PLOT PLAN DRAWING CHECKLIST

PRR-19-55

Plot Plan

Site Development Plan for Wild Blue Animal Rescue

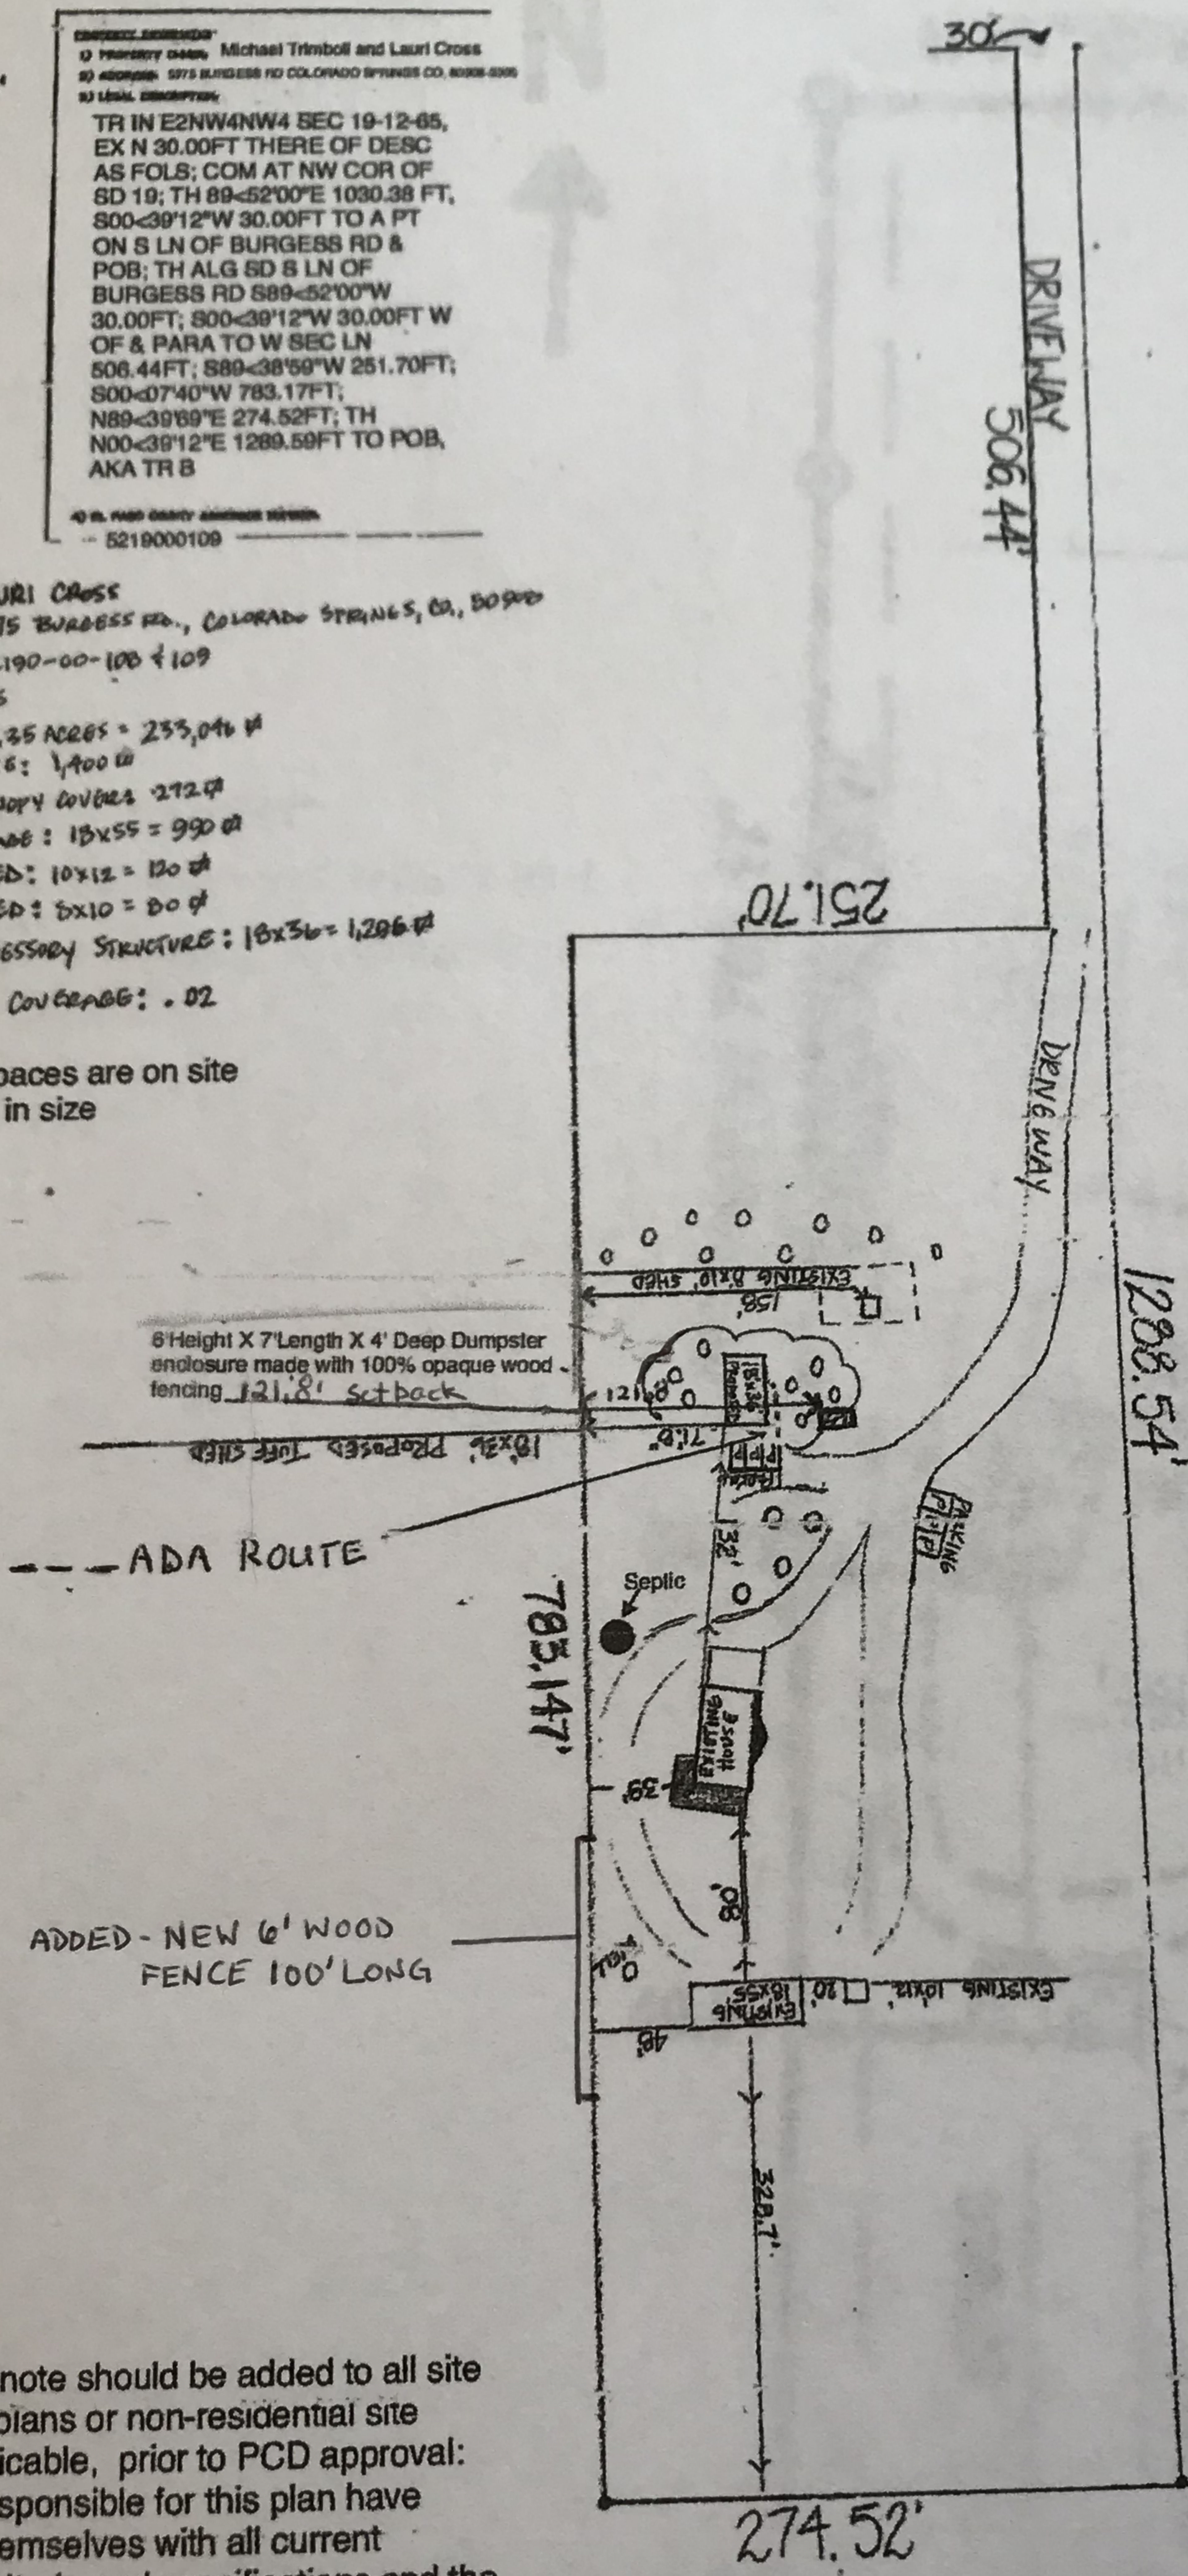
measurement to prop lines

are there sidewalks from B L O 6 to B 10 4 to parking ?

? Show sign None
